COUNTY COUNCIL'S RESPONSE TO CONSULTATION ON THE FOLLOWING DEVELOPMENT PROPOSAL

Application No: 19/02796/F

Proposal: Erection of sports & community pavilion with associated carpark and sport facilities (outdoor pitches and MUGA) following planning consent for change of use of agricultural land to sport/recreation and community use (18/00220/F)

Location: OS Parcels 3309 And 4319 Adjoining and North Of Milton Road
Adderbury

Title Refuse Vehicle Swept Path
Analysis Entry

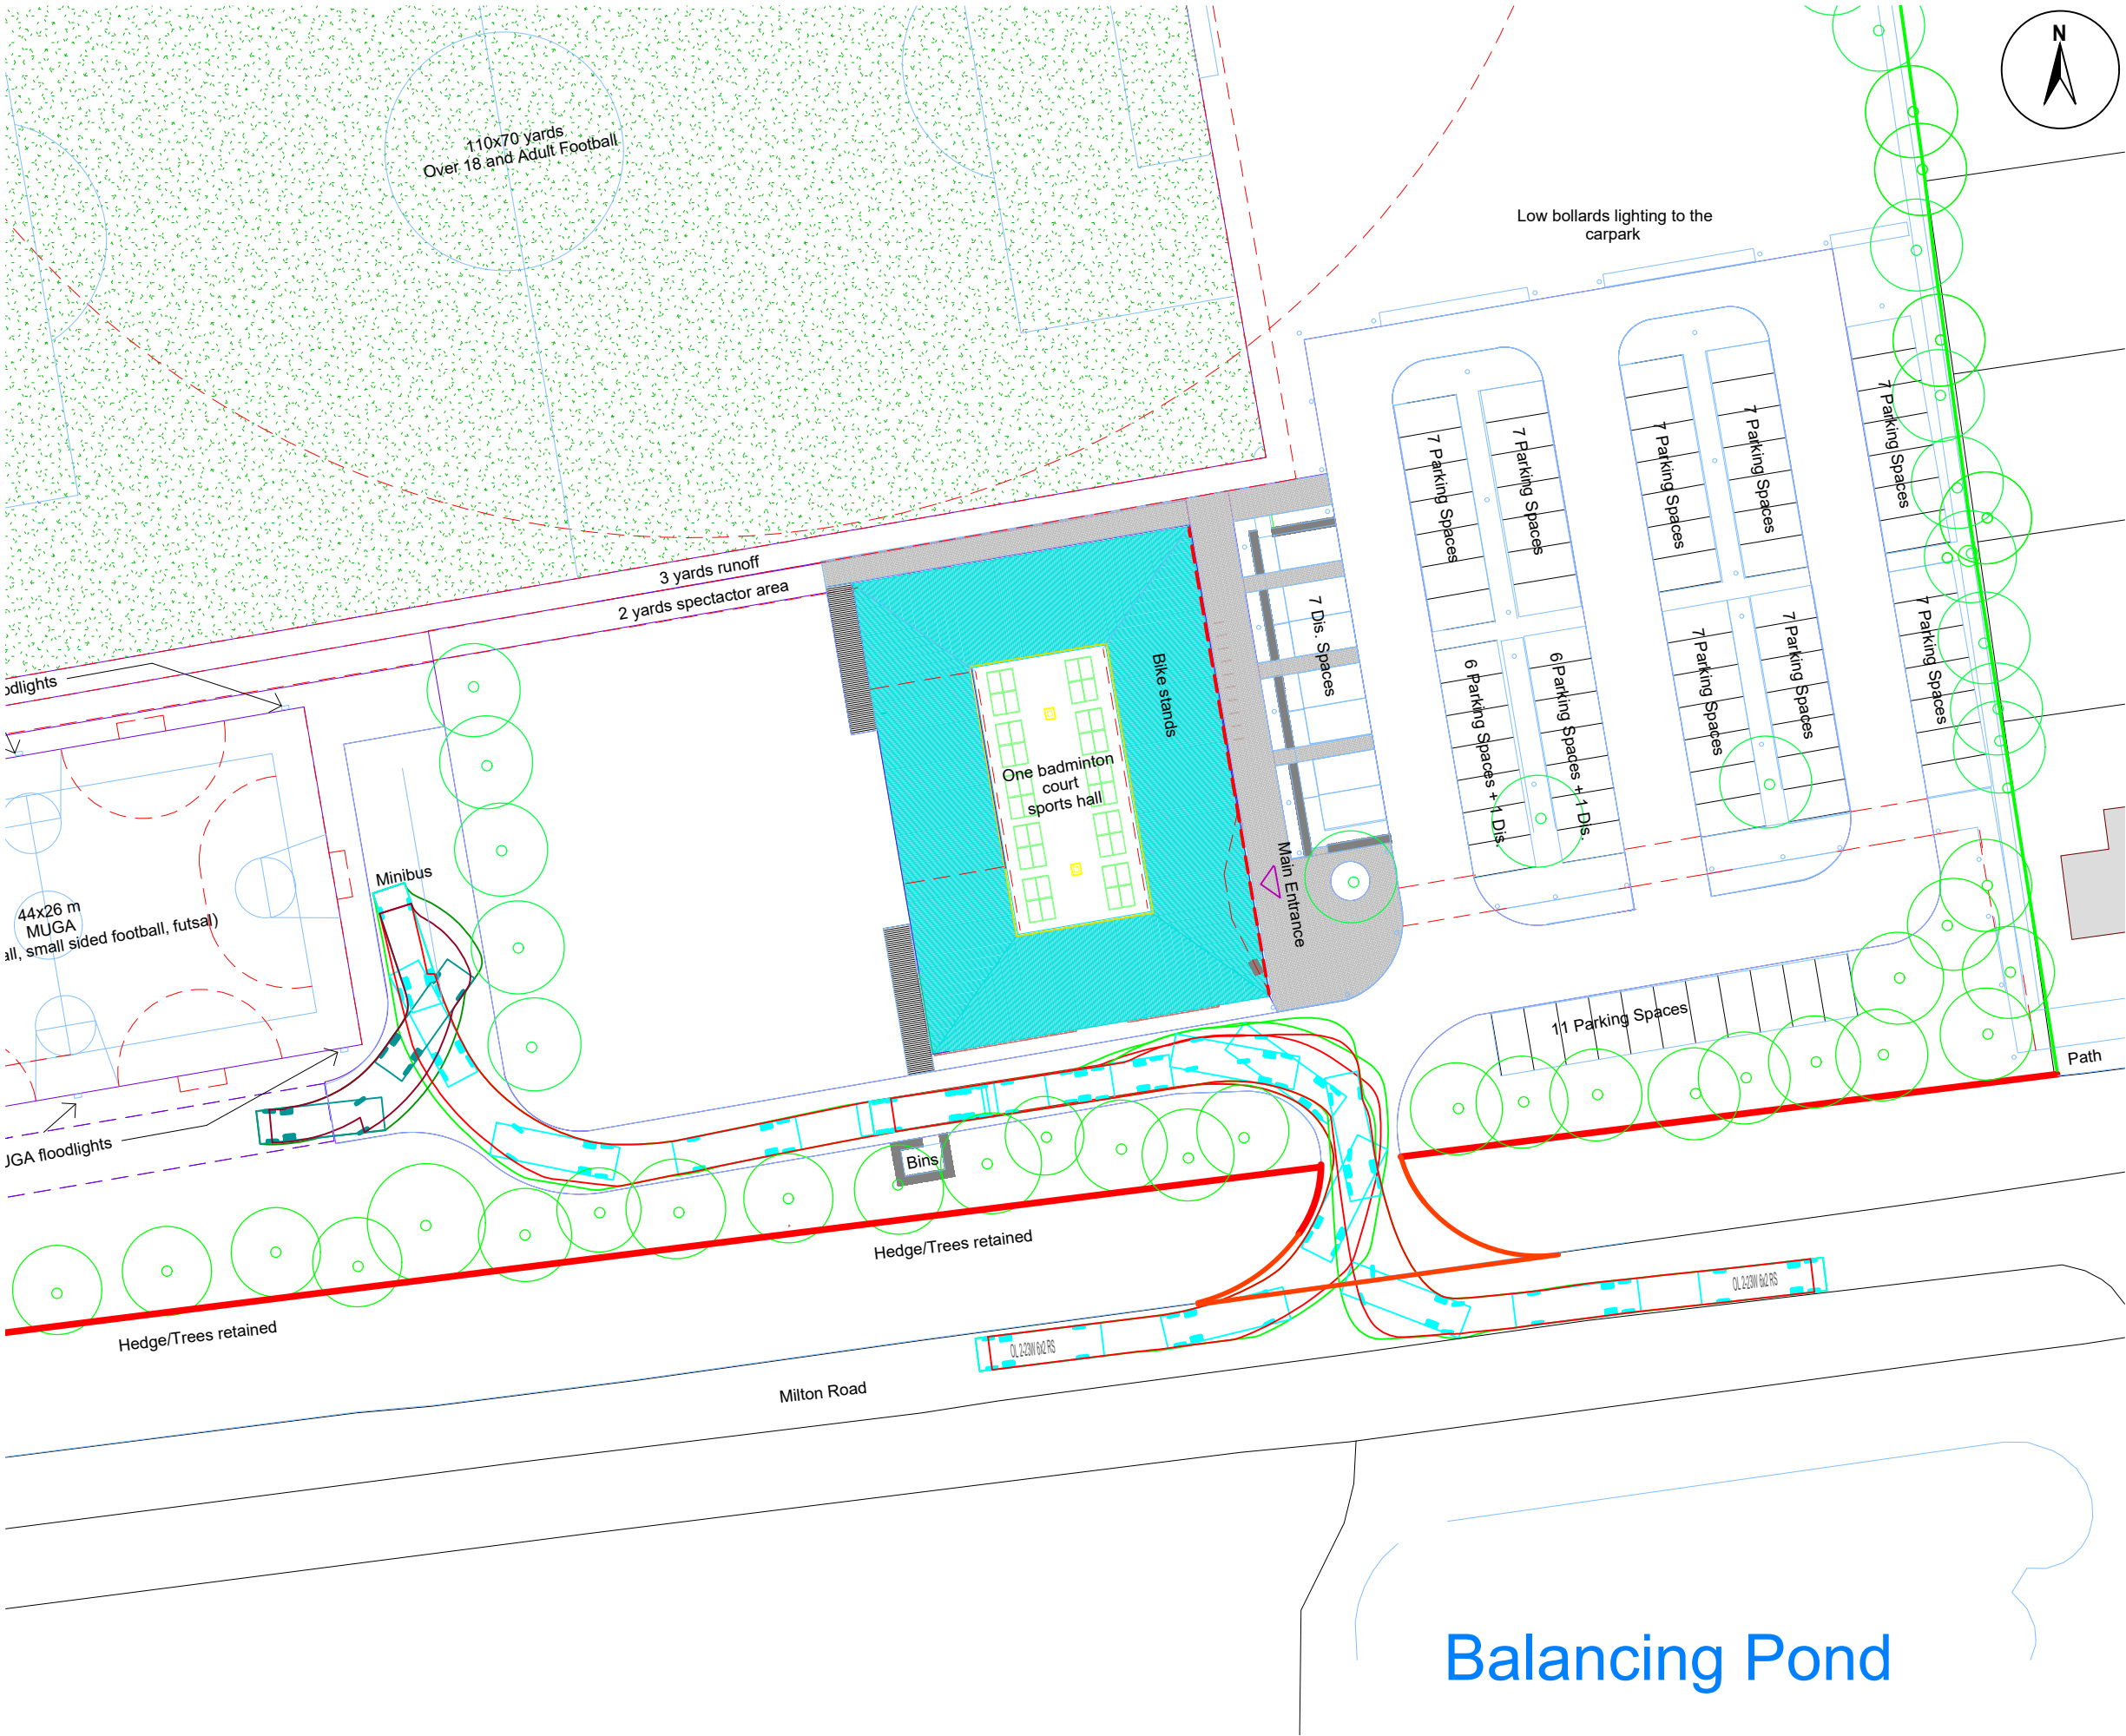
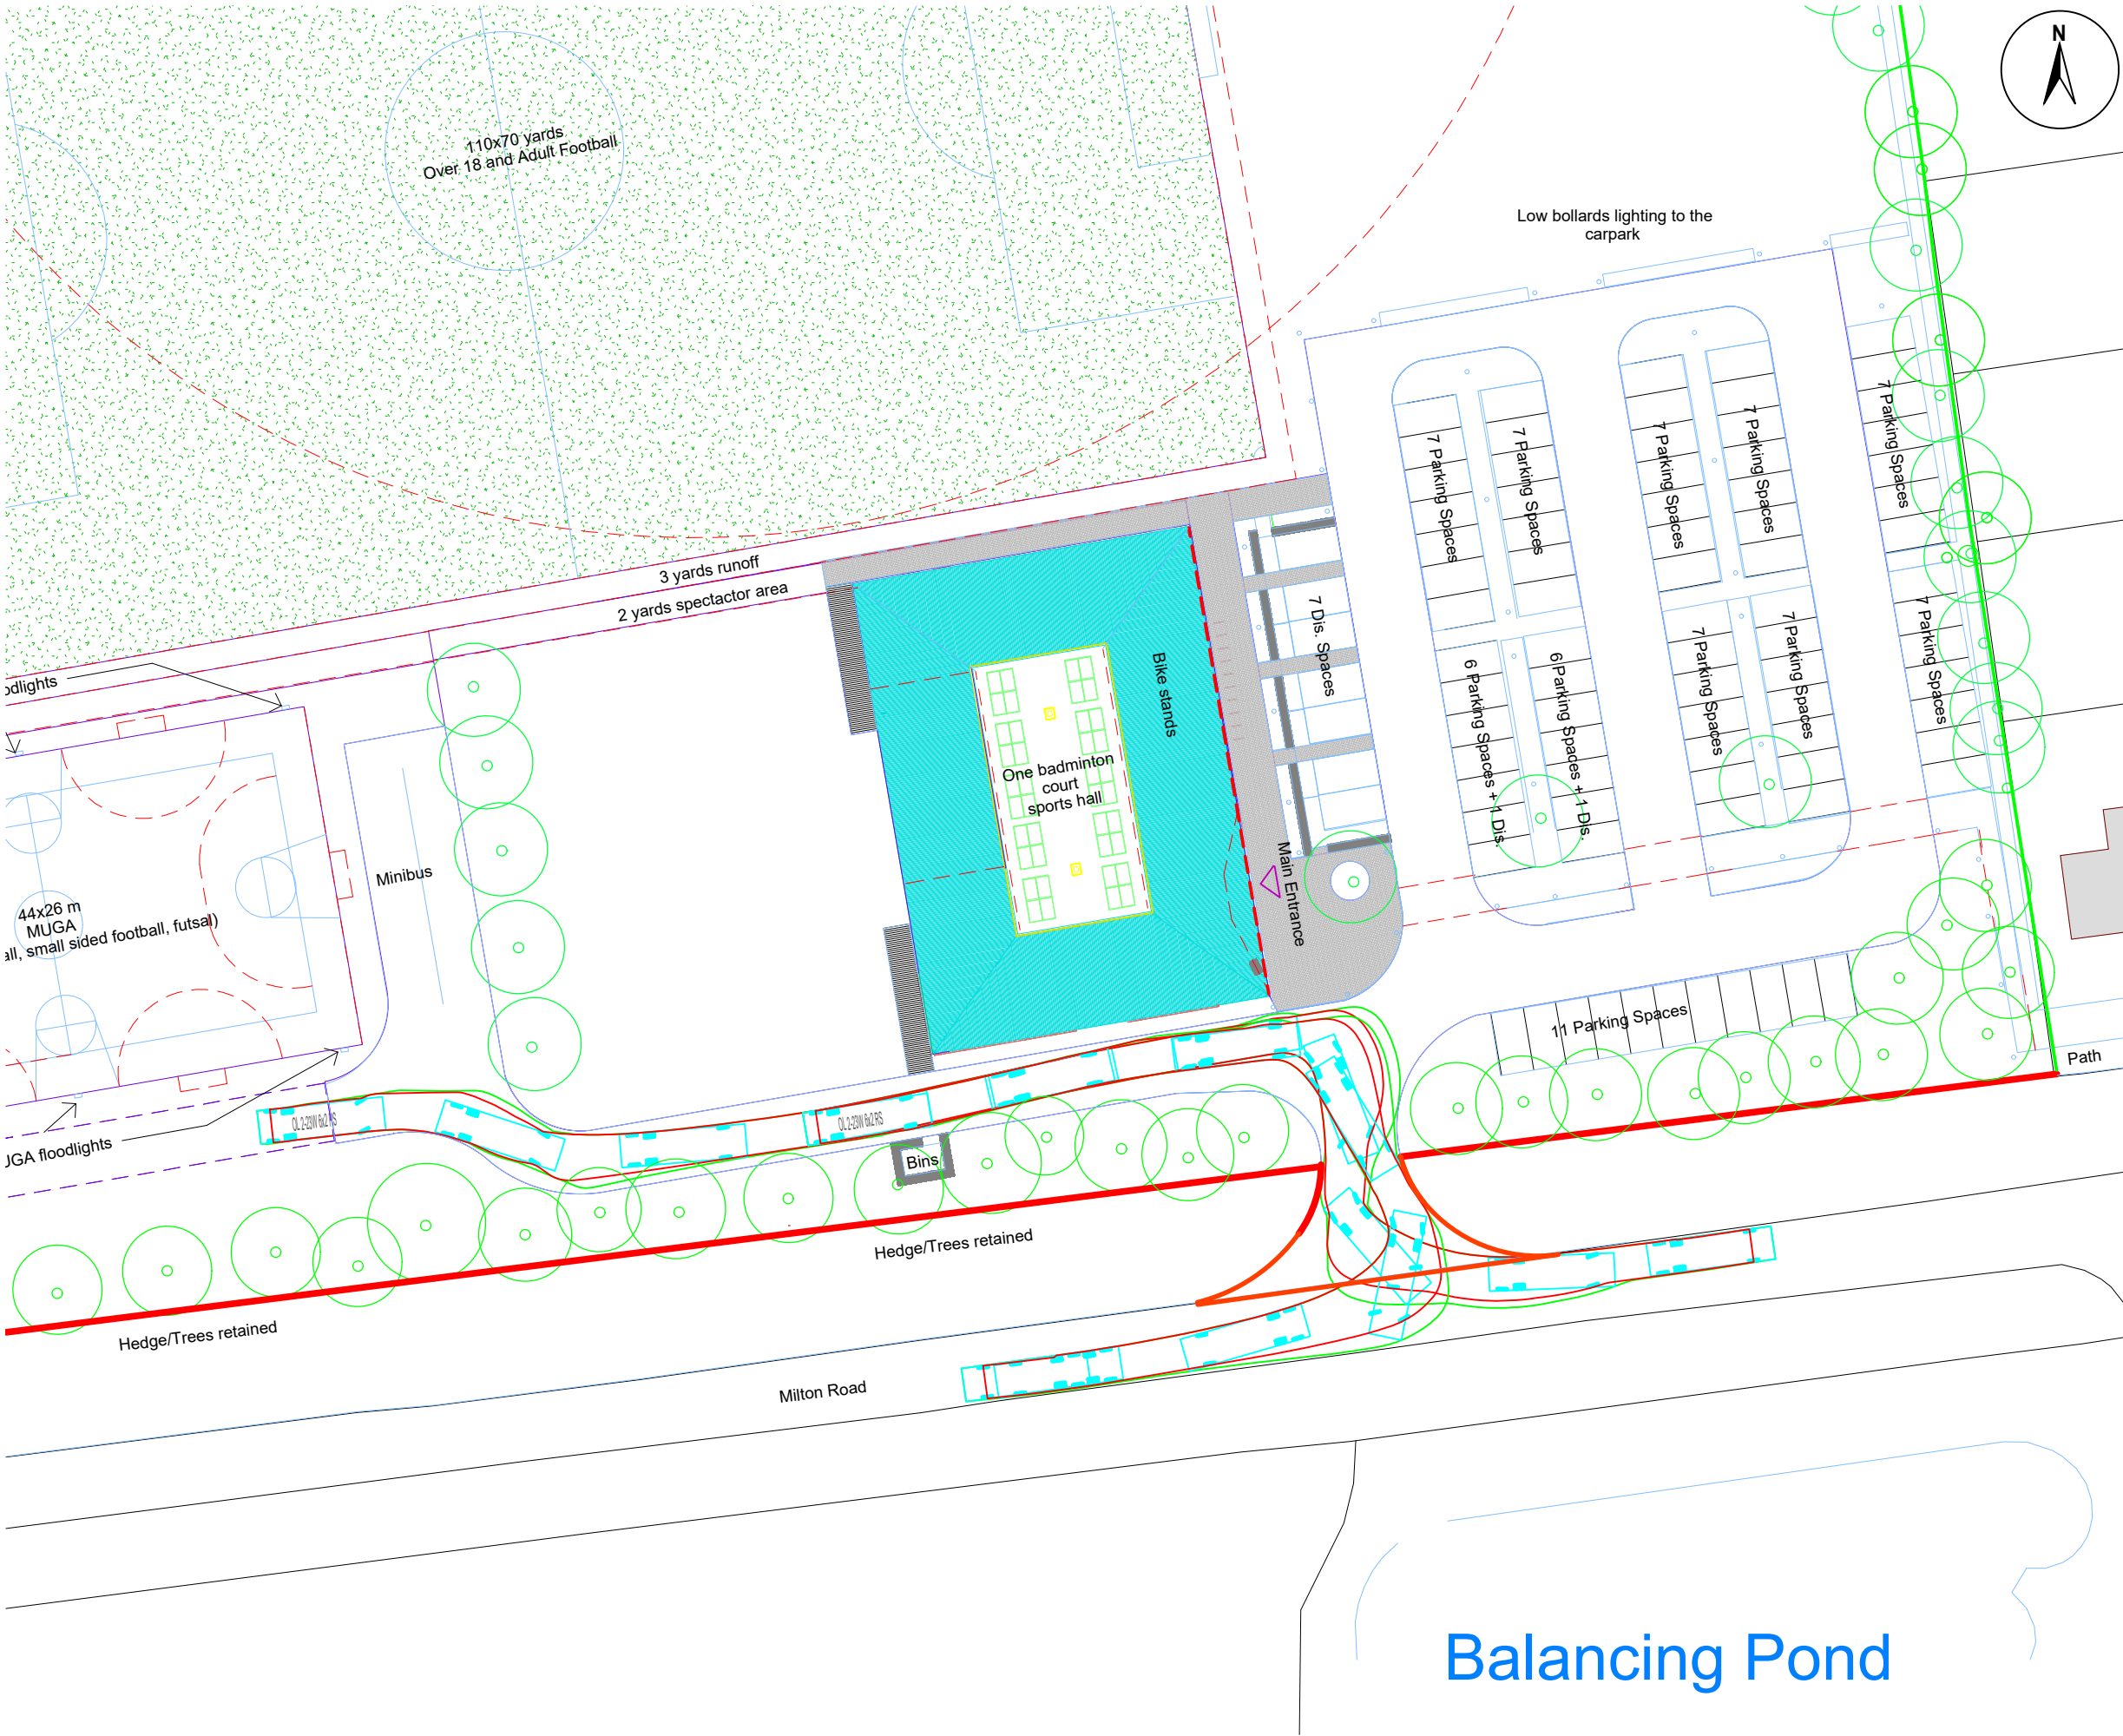
The proposed site layout has been modified since the approved change of use application (18/00220/F) and the previous pre-application advice (19/00166/PREAPP). The latest version, drawing no. 7354(08)02 Rev. D maintains the same number of parking spaces in what appears to be a more logical arrangement in terms of access and car parking. It has been demonstrated how a Refuse Collection Vehicle can turn within the site, and the location of the bins.
